Your ref: SSD-33042483 Our ref: DOC22/721855

Subject: Major Projects – New Request for Advice - Manildra - Port Kembla Bulk Liquid Terminal (SSD-33042483) (Wollongong City)

ATTACHMENT A BCD Assessment Summary for Manildra - Port Kembla Bulk Liquid Terminal Environmental Impact Statement (SSD 33042483)

ATTACHMENT B Detailed comments for Manildra - Port Kembla Bulk Liquid Terminal Environmental Impact Statement (SSD 33042483)

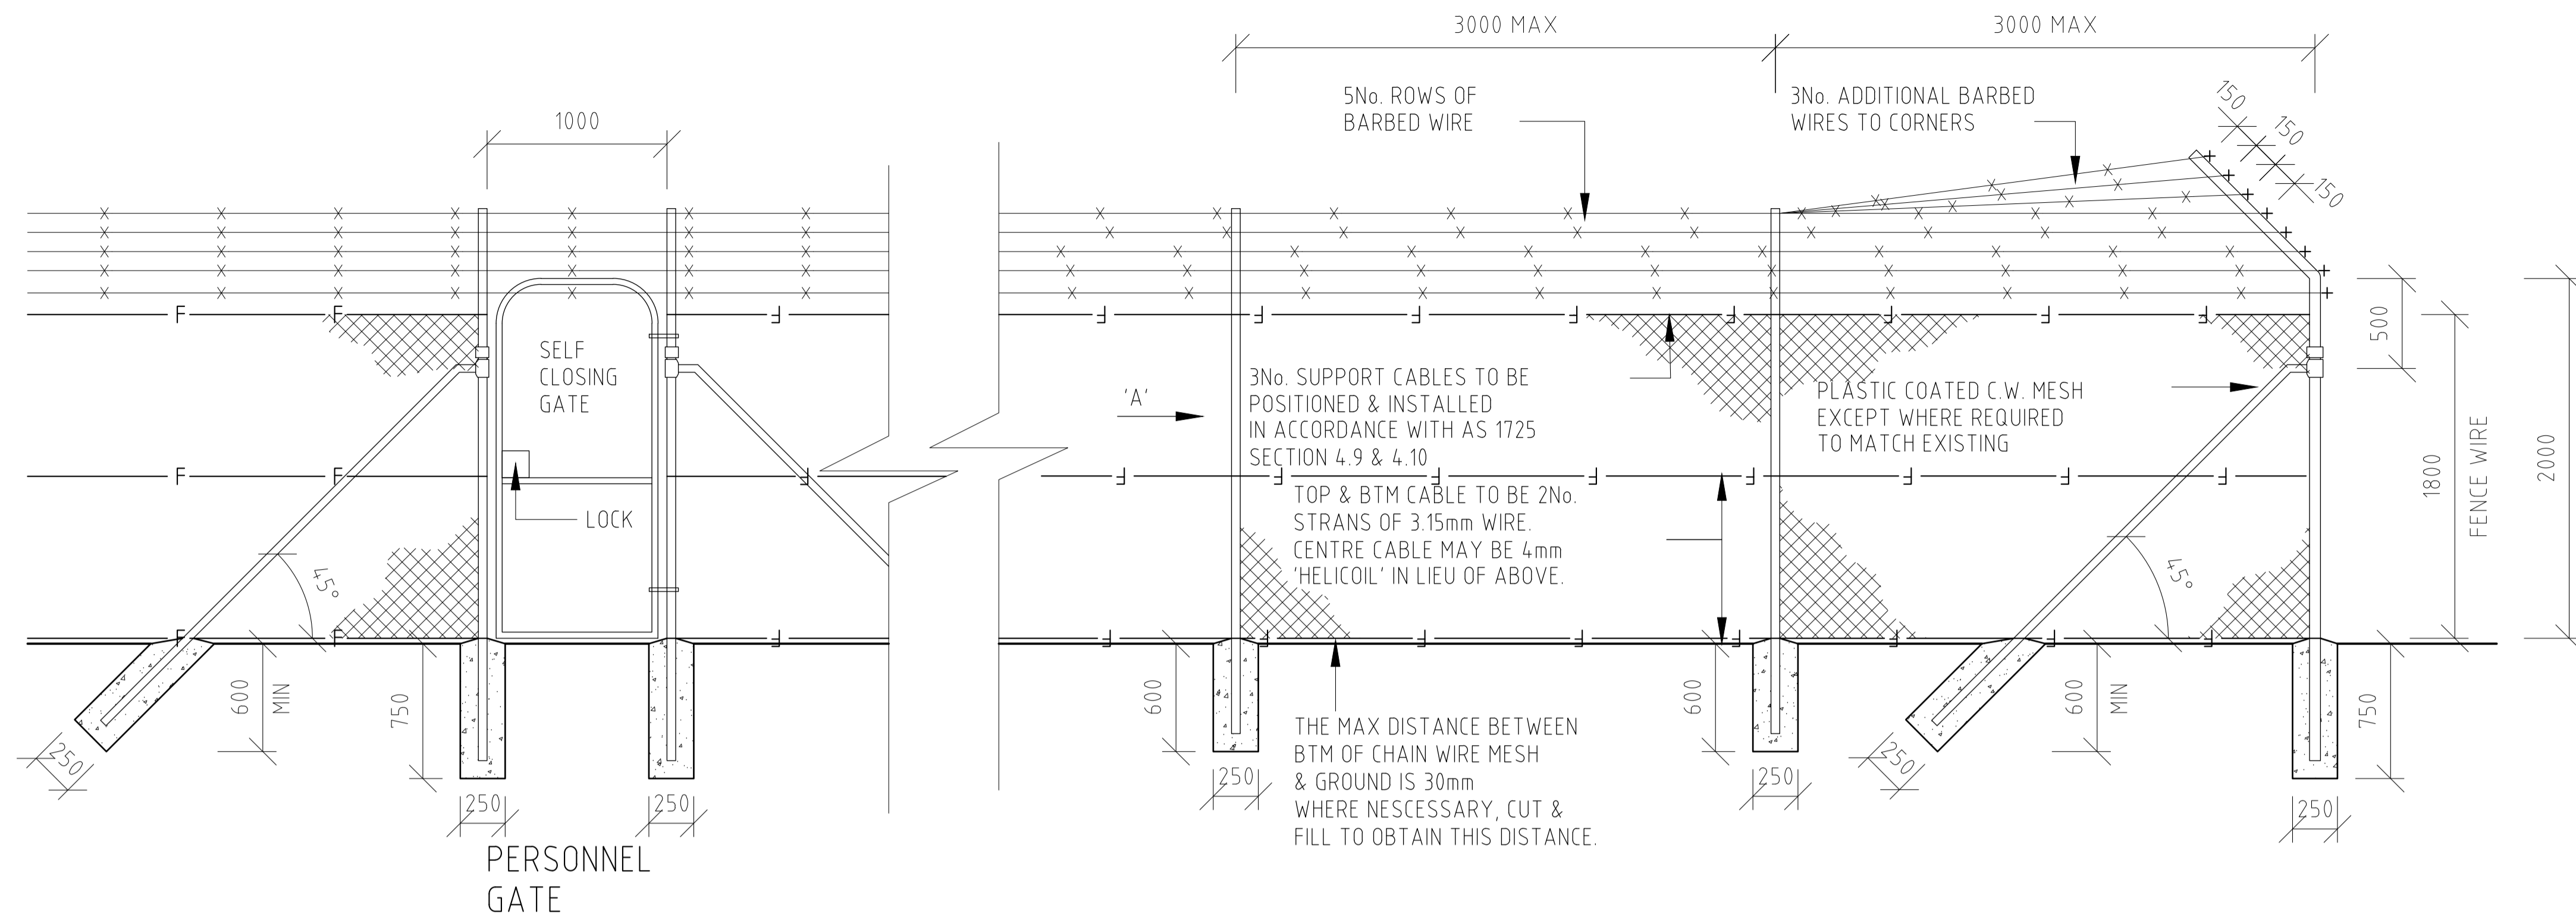
7.	Coastal Risk Management – sea level rise and flooding	 The EIS also contains a very limited discussion on sea level rise and flooding. It is unclear whether sea level rise has been taken into account when designing infrastructure, for example will stormwater management structures such as the GPTs still be effective into the future. Recommended action: Provide discussion on sea level rise and flooding (taking into account infrastructure such as stormwater management structures).
	Extent and Timing	Pre-determination

8.	Coastal Risk Management – sea level rise and flooding	 The EIS should consider the background condition of the receiving waterbody for the stormwater discharge and proposed monitoring to ensure stormwater management controls are affective. Recommended action: Provide details of consideration of the background condition of the receiving waterbody for the stormwater discharge and proposed monitoring to ensure stormwater management controls are affective.
	Extent and Timing	Pre-determination

the environment from the hazardous material to be stored on site, there should be consideration of the structural integrity of storage facilities to withstand extreme events, and control and remediation measures should structures fail. We note the area is mapped as Coastal Environment Area under the Chapter 2 of the Resilience and Hazard SEPP and as such the development proposal should demonstrate it will not cause an adverse impact on the water quality. The EIS also contains a very limited discussion on sea level rise and flooding. It is unclear whether sea level rise has been taken into account when designing infrastructure, for example will stormwater management structures such as the GPTs still be effective into the future.

Impacts on the receiving surface water body and how these can be minimised. The EIS should consider the background condition of the receiving waterbody for the stormwater discharge and proposed monitoring to ensure stormwater management controls are affective. We understand treatment is via Humegard units and note annual cleaning of units is proposed. There does not appear to be any monitoring of the effectiveness of the treatment units.
